**RE: 6/2020/3439/COND – Northaw House, Coopers Lane, Northaw, Potters Bar, EN6 4NG**

Thank you for consulting us on the above application for the submission of details pursuant to condition 1 (surface water drainage scheme) on planning permission 6/2019/0217/MAJ at Northaw House, Coopers Lane, Northaw, Potters Bar, EN6 4NG.

We note we were previously consulted on the discharge of condition 1 as part of application 6/2020/1181/COND. It is now proposed to relocate and enlarge the proposed attenuation pond.

Section C-C - Typical Dry Swale Detail (1:20)

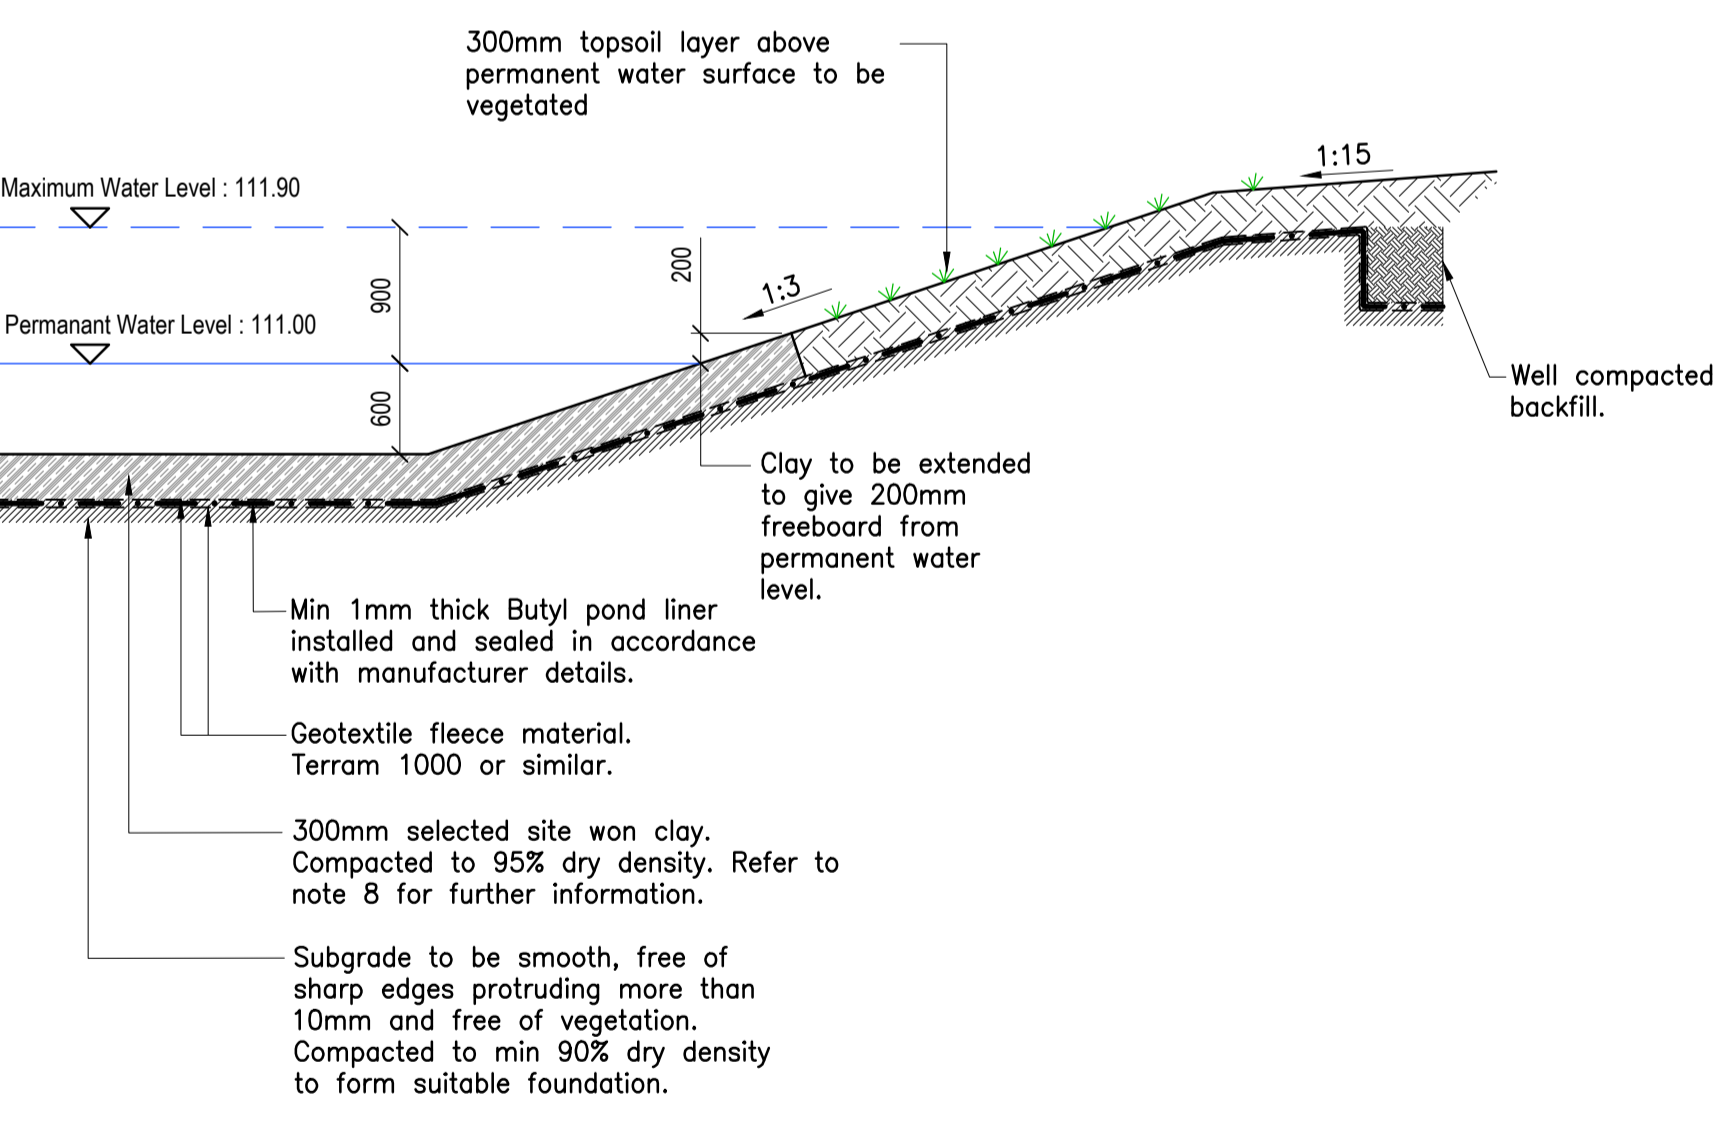
The applicant has also clarified that the eastern swale is to provide an exceedance flow function only and will not convey flows from the access road under normal circumstances. We would prefer this swale to provide surface water conveyance as a function of the site network thereby providing additional SuDS management and treatment, however we are happy the proposed pond will provide sufficient treatment according to the treatment indices.
